**City of Portland, Maine - Building or Use Permit Application**  
 389 Congress Street, 04101 Tel: (207) 874-8703, Fax: (207) 874-8716

Permit No: 03-0424	Issue Date: <b>APR 30 2003</b>	CBL: 297 D012001
-----------------------	-----------------------------------	---------------------

Proposed Project Description: Build a 22' x 26' one story garage and demolish existing non-conforming	PEDESTRIAN ACTIVITIES DISTRICT (P.A.D.) Action: <input type="checkbox"/> Approved <input type="checkbox"/> Approved w/Conditions <input type="checkbox"/> Denied Signature: _____ Date: _____
--	---

**Dept:** Zoning      **Status:** Approved with Conditions      **Reviewer:** Jeanine Bourke      **Approval Date:** 04/30/2003

**SKETCH PLAN**  
 100 Hicks Street  
 Portland, Maine  
 for  
 John Brewer

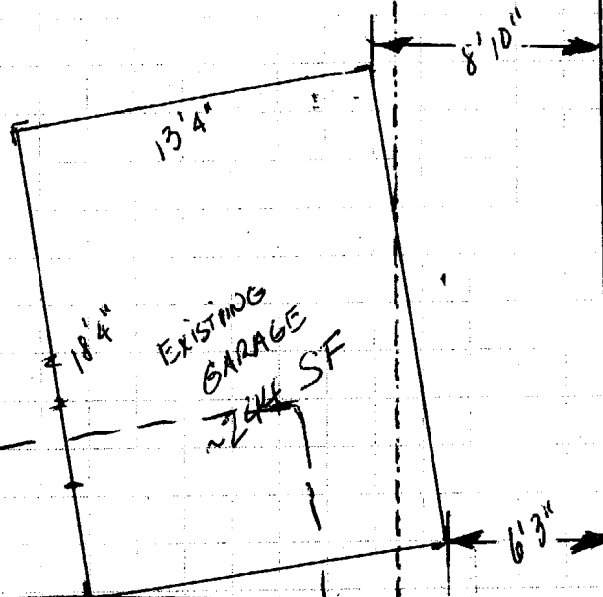
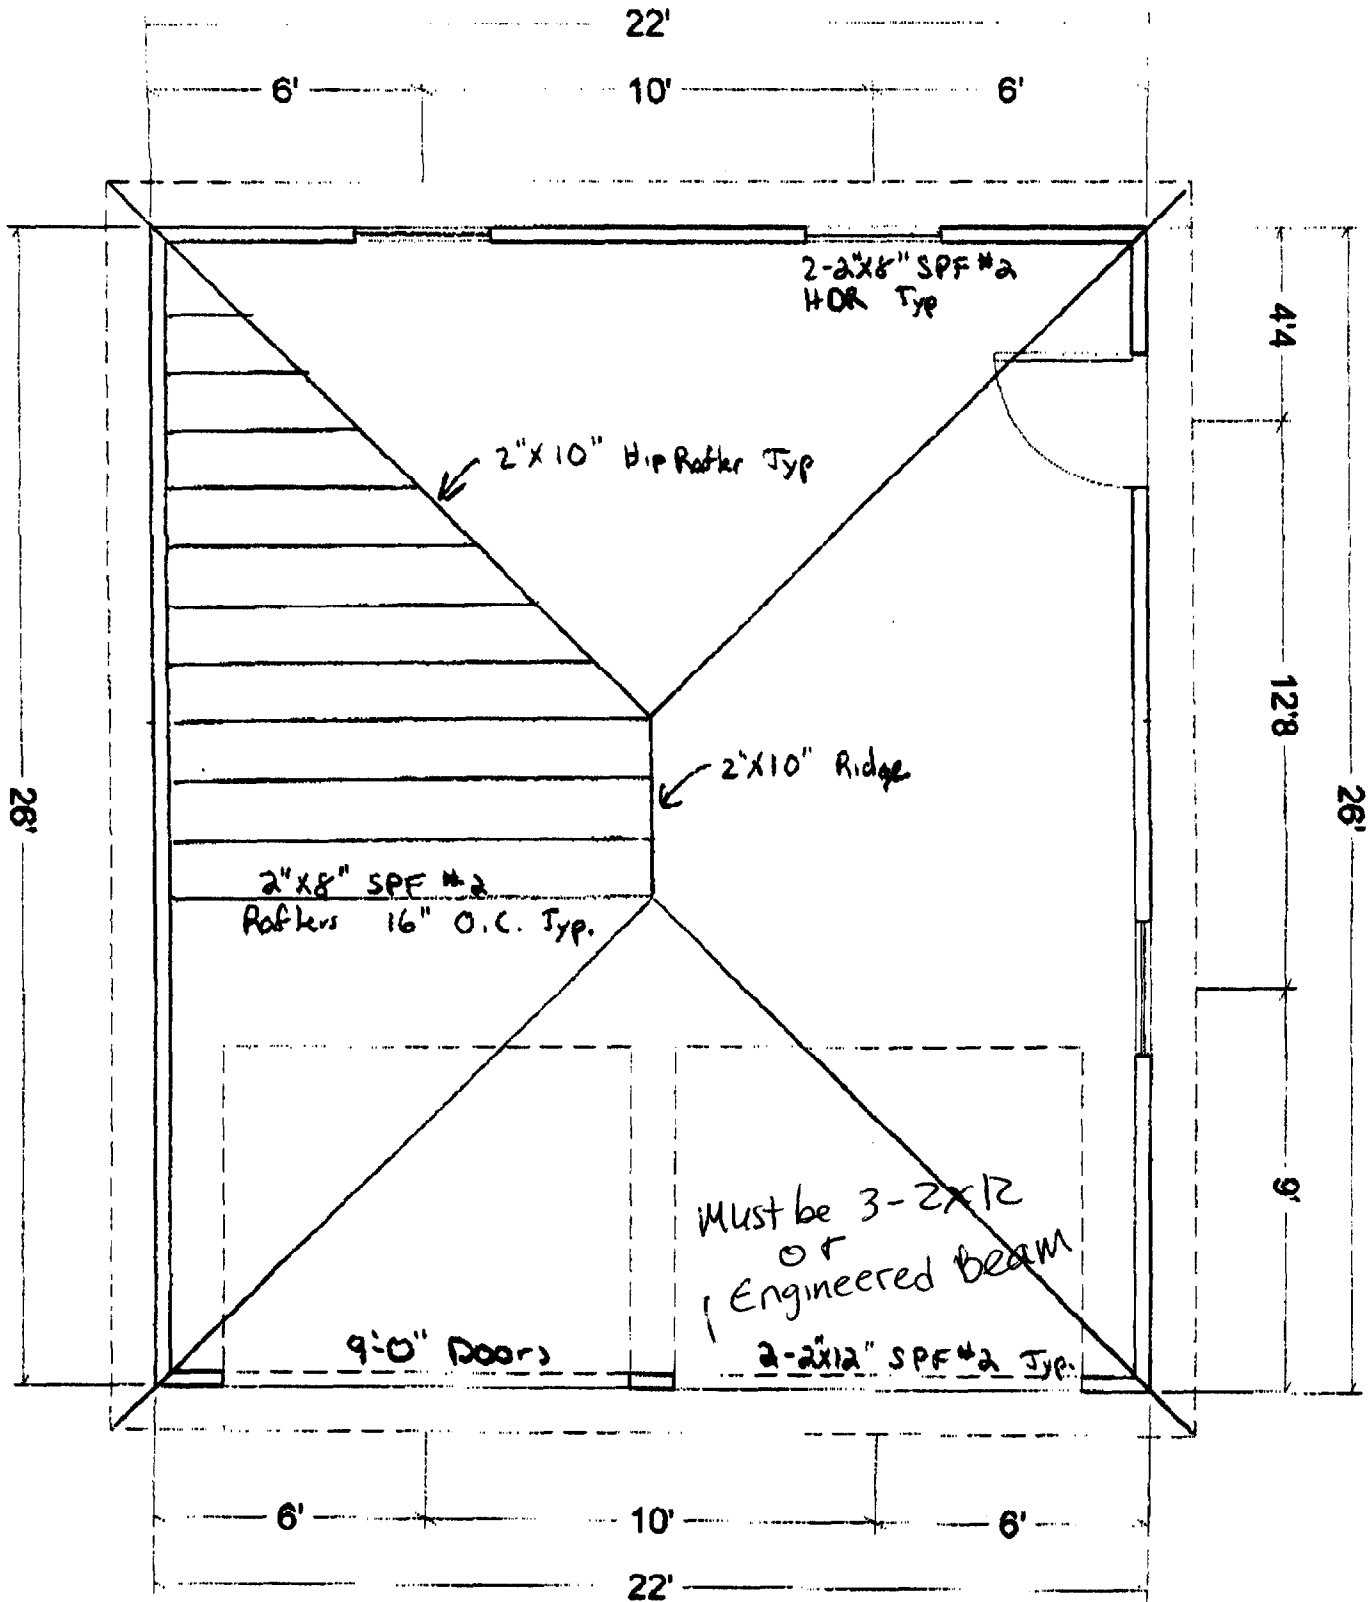
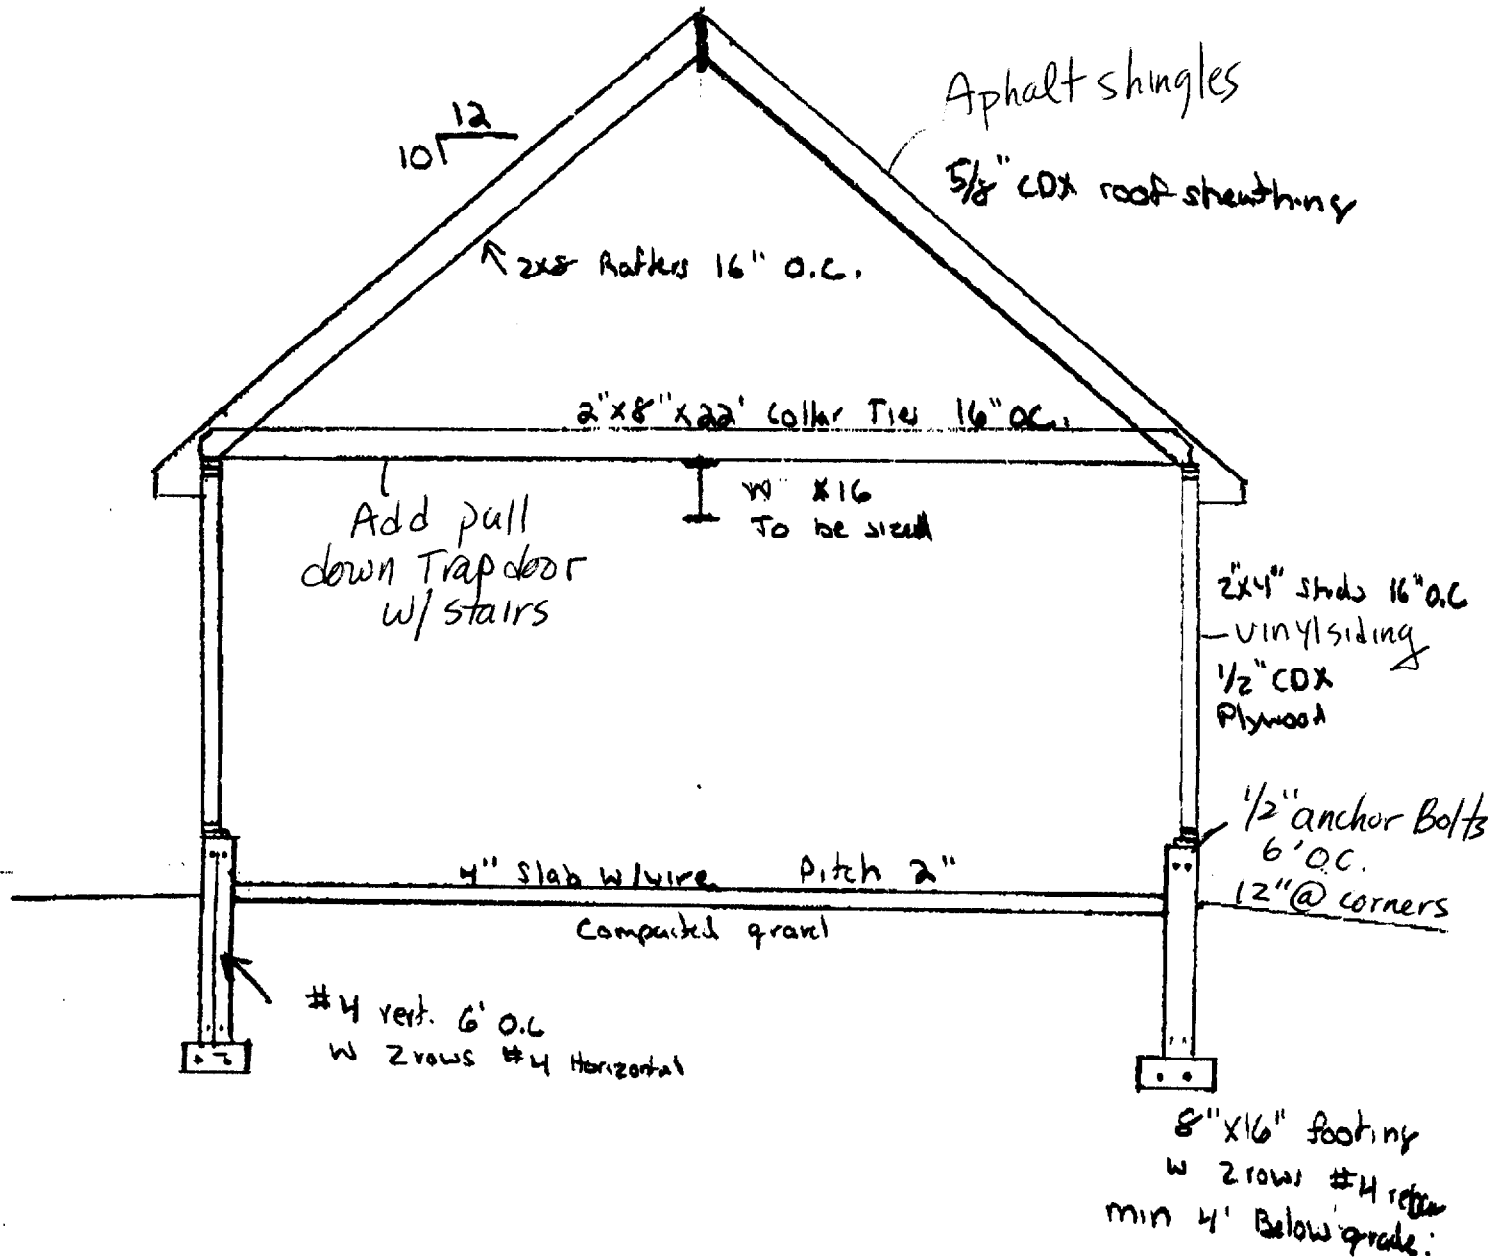
- 1) If the sided setback is reduced to less than 9' this office will require a surveyor to set the pins for the walls or provide a letter stating the as built compliance to the required setback.
- 2) This property shall remain a single family dwelling. Any change of use shall require a separate permit application for review and approval.
- 3) Existing non-conforming garage to be demolished. Build a new garage to meet the 8' side setback and refer to section 14-433 to reduce the rear setback to 10' in order to increase the ability to negotiate around the house with vehicles to enter the garage.

- 1) The 9' garage door header must be a min. Of 3-2x12 or and engineered product. The specs on the steel beam must be submitted to this office.
- 2) Separate permits are required for any electrical work.
- 3) Application approval based upon information provided by applicant. Any deviation from approved plans requires separate review and approval prior to work.
